20130328.1/1206A/R2/TA

12/06/2013

Sydney International Convention Centre - Supplementary Acoustic Report

AUSTROADS 2006 19.0m SEMI -
01 IN FROM DARLING DRIVE @ 15km/hr
1 : 500

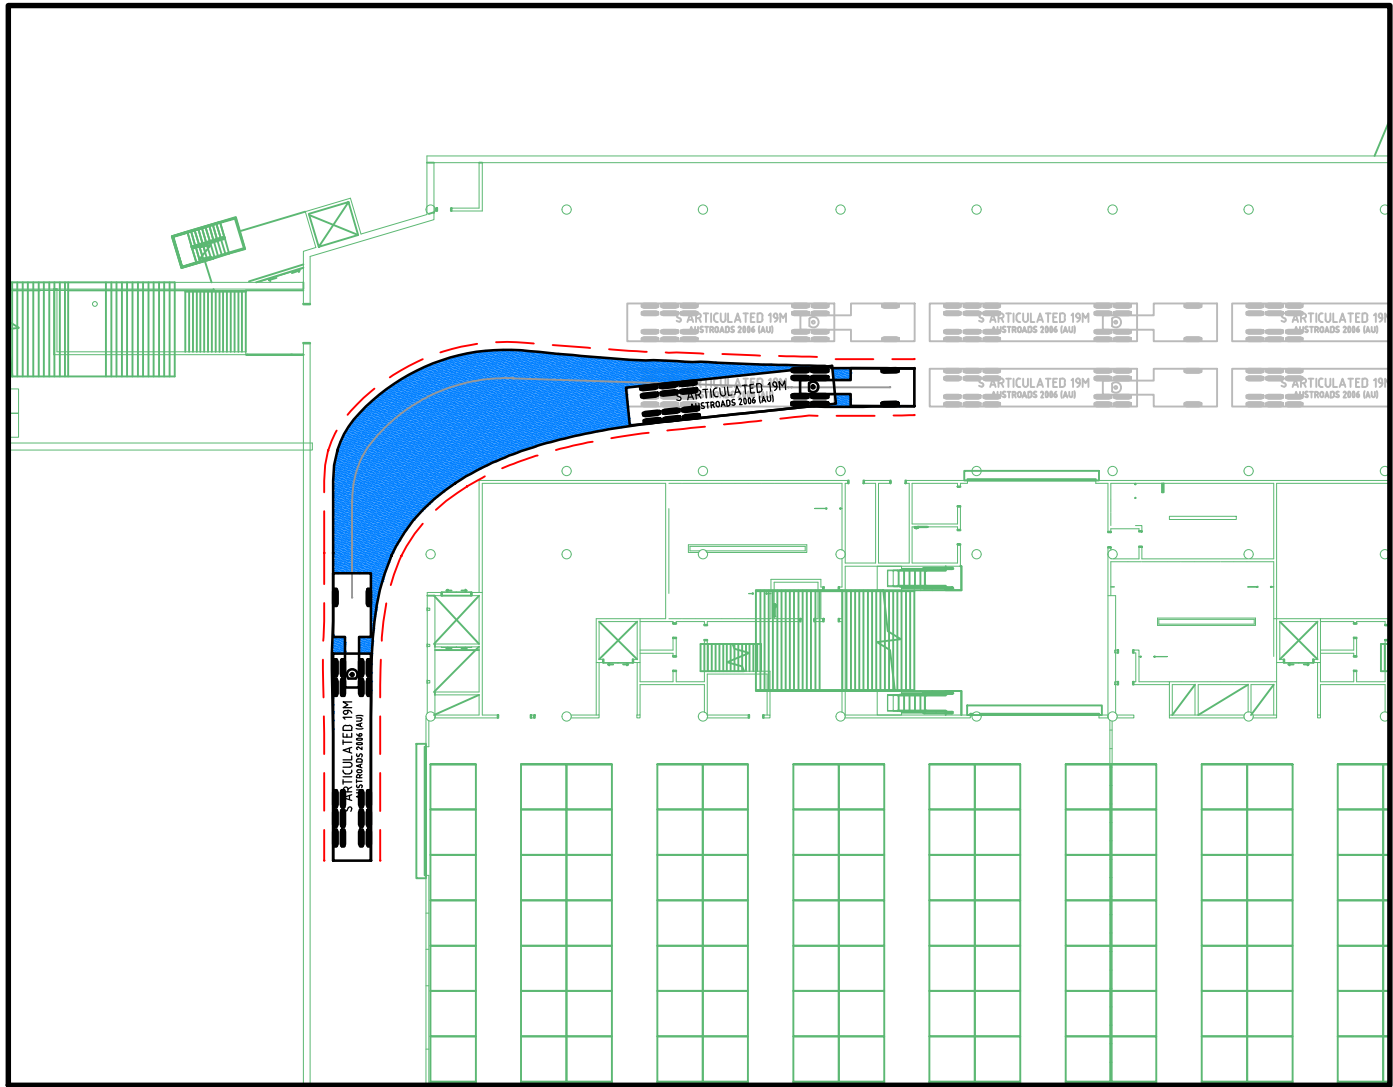
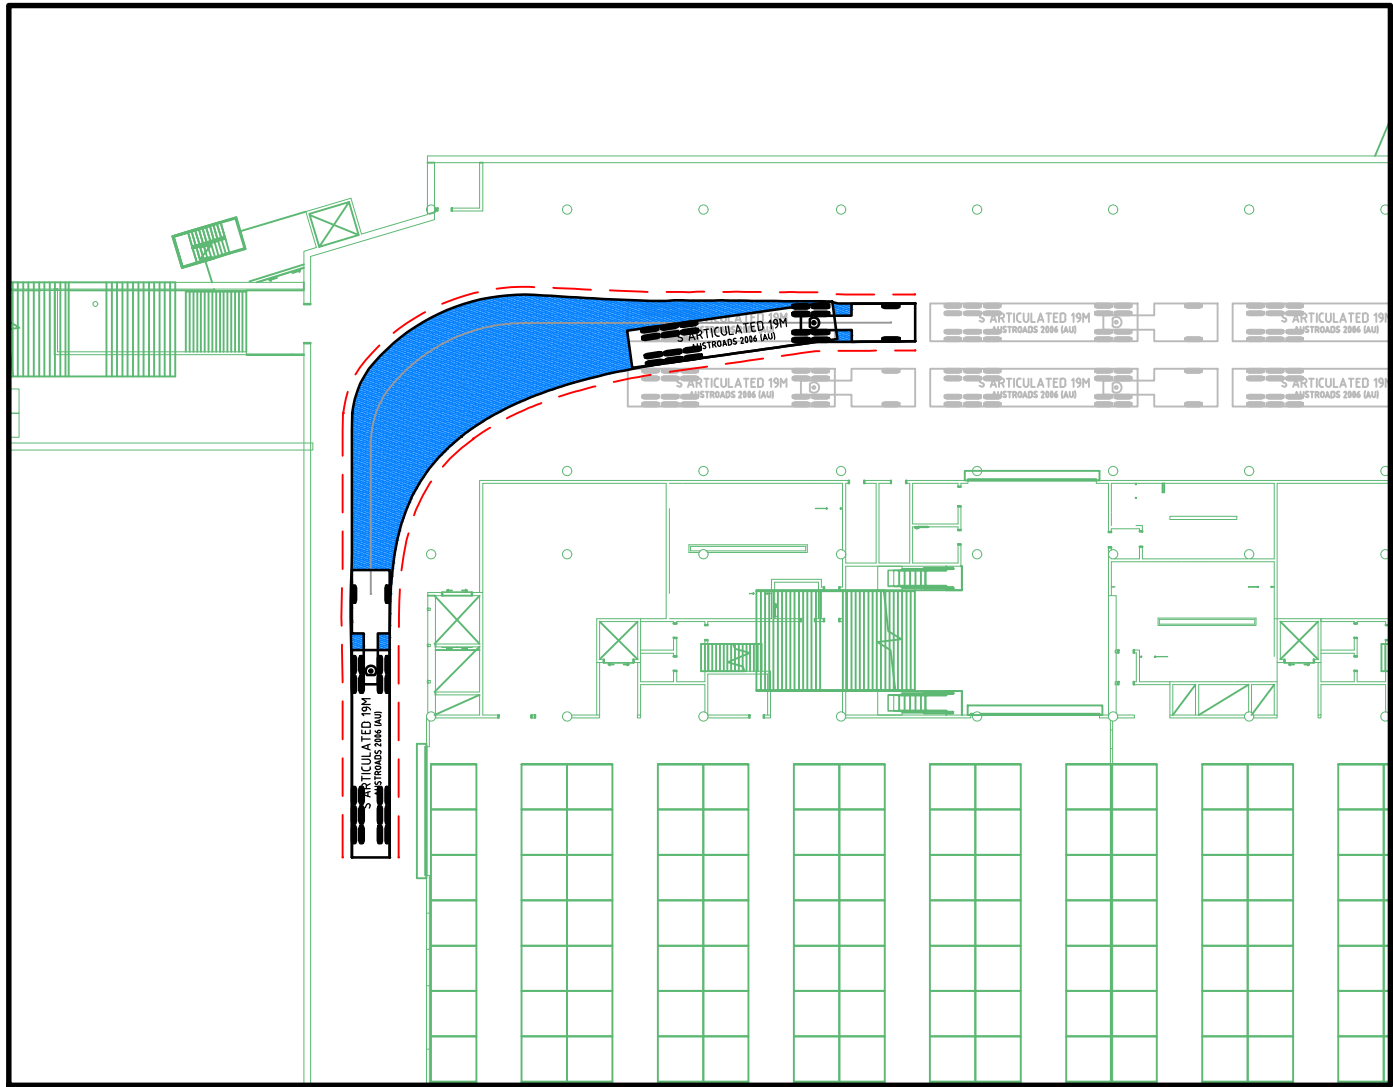
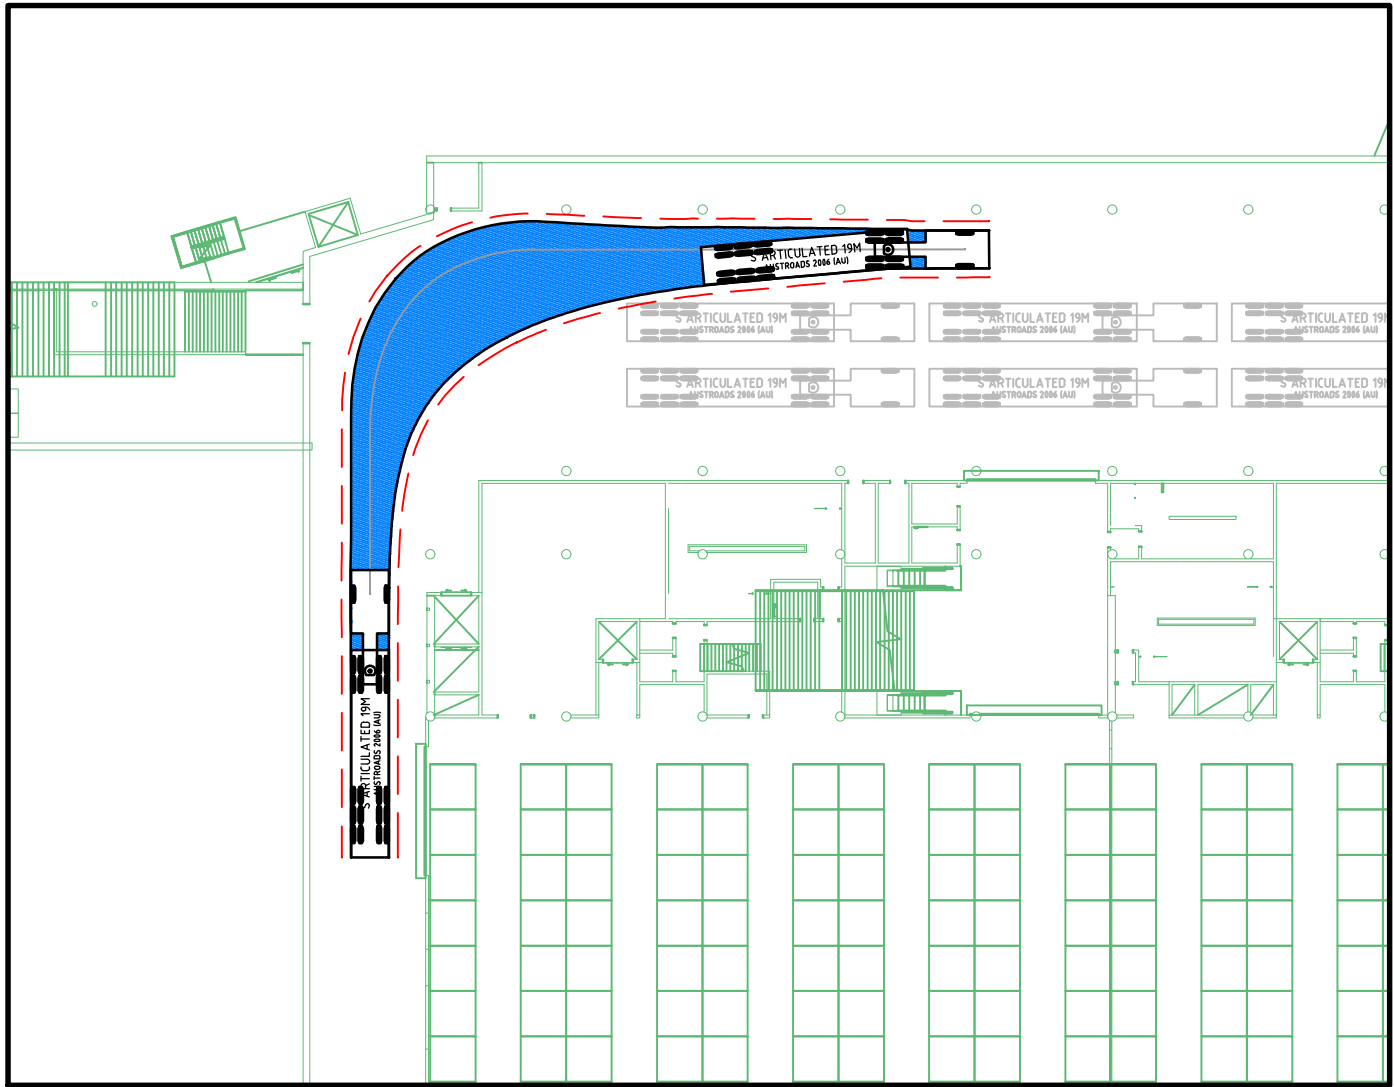
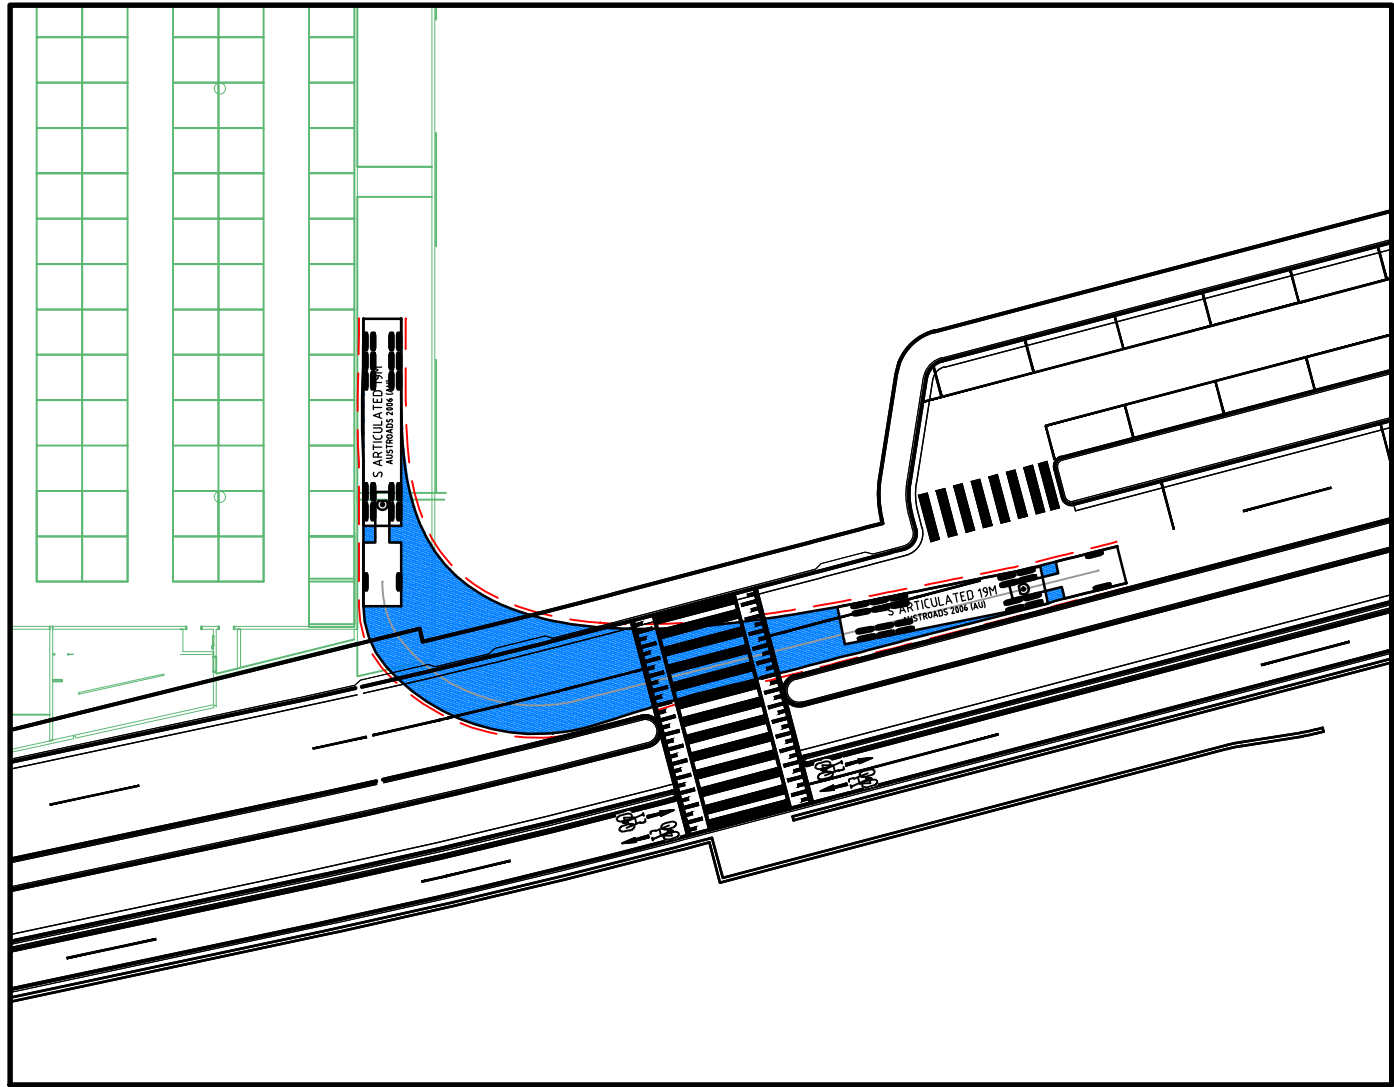
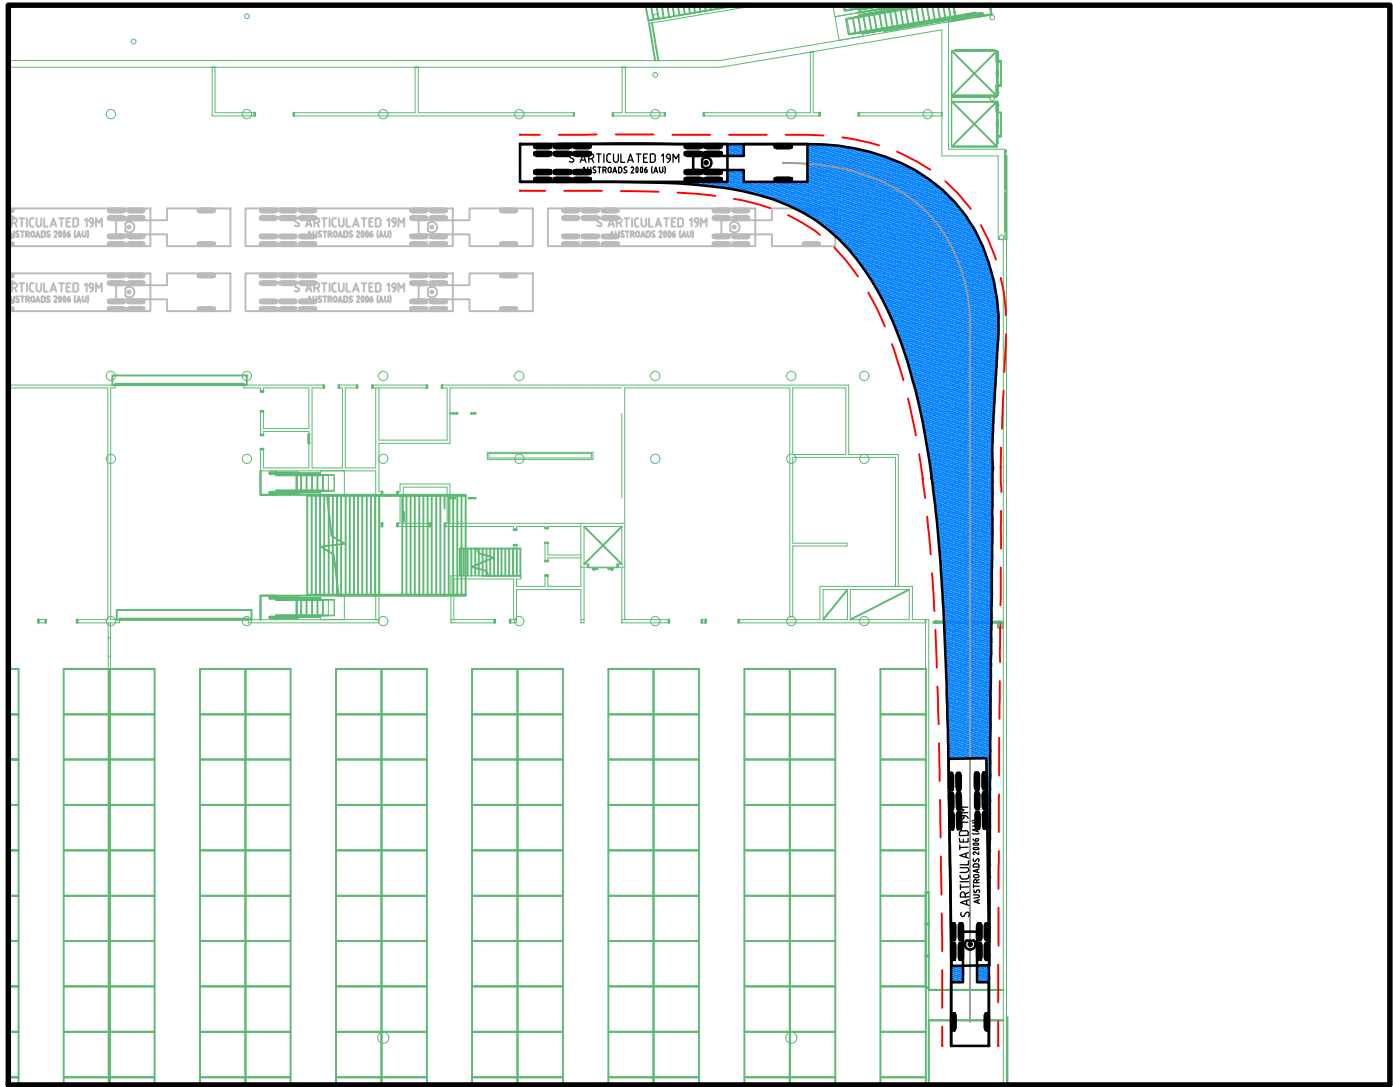
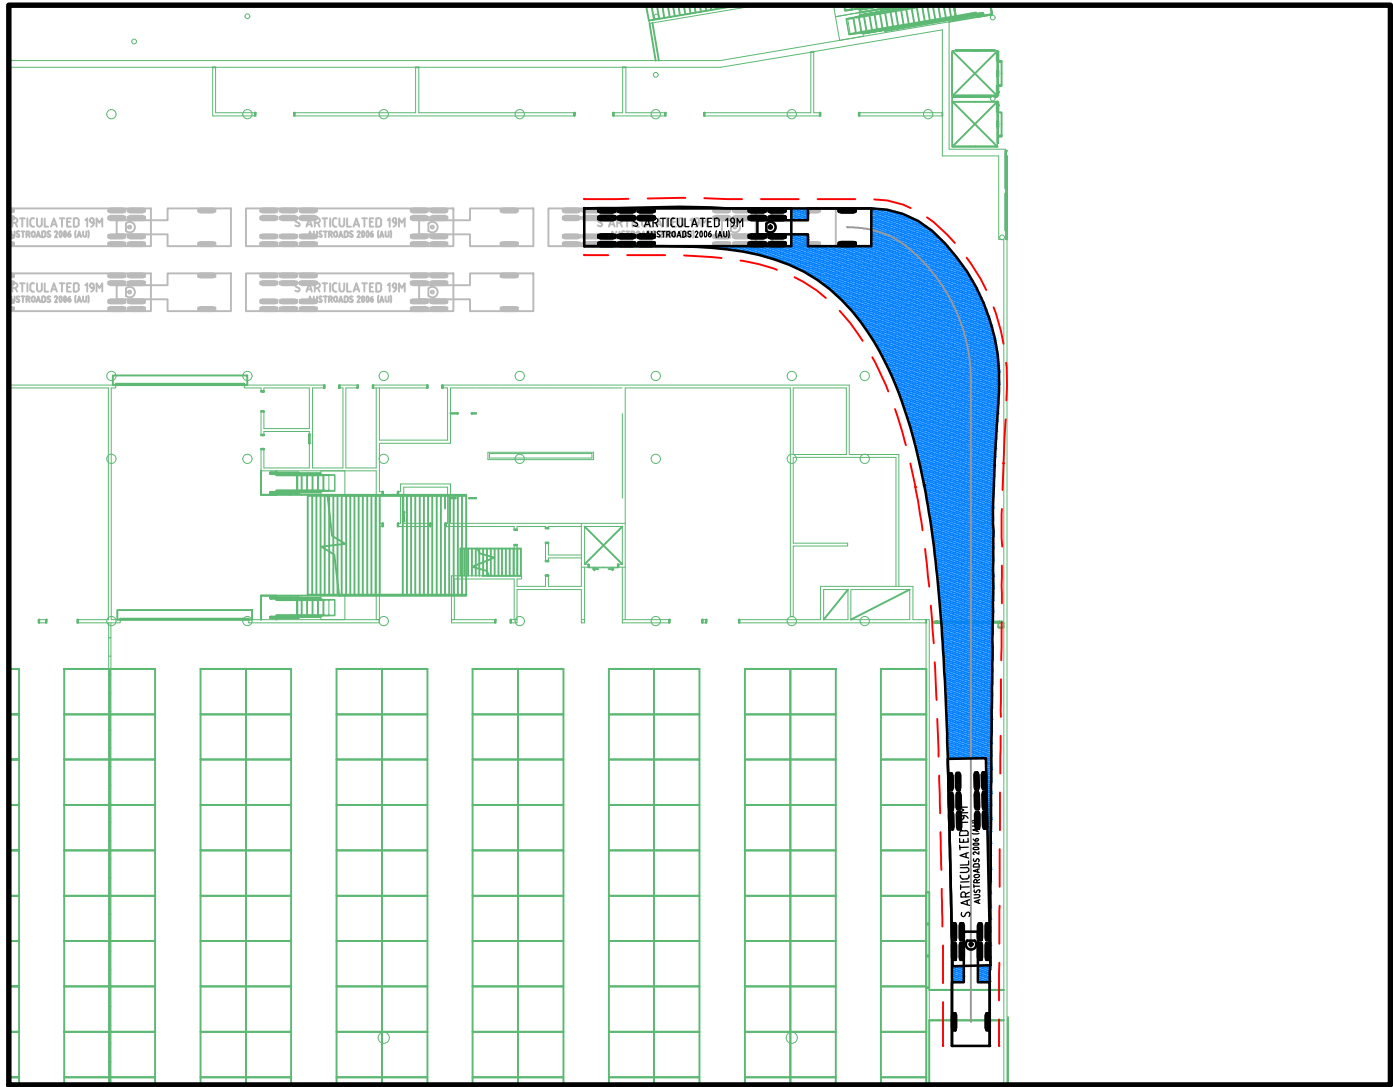
Confirm whether or not the at-grade loading areas off Darling Drive for the Convention Centre will be designed to allow trucks to enter and leave in a forward motion so as to minimise amenity and safety impacts.

DHL confirm that at grade loading areas off Darling Drive are designed to allow trucks to enter and leave in a forward motion.
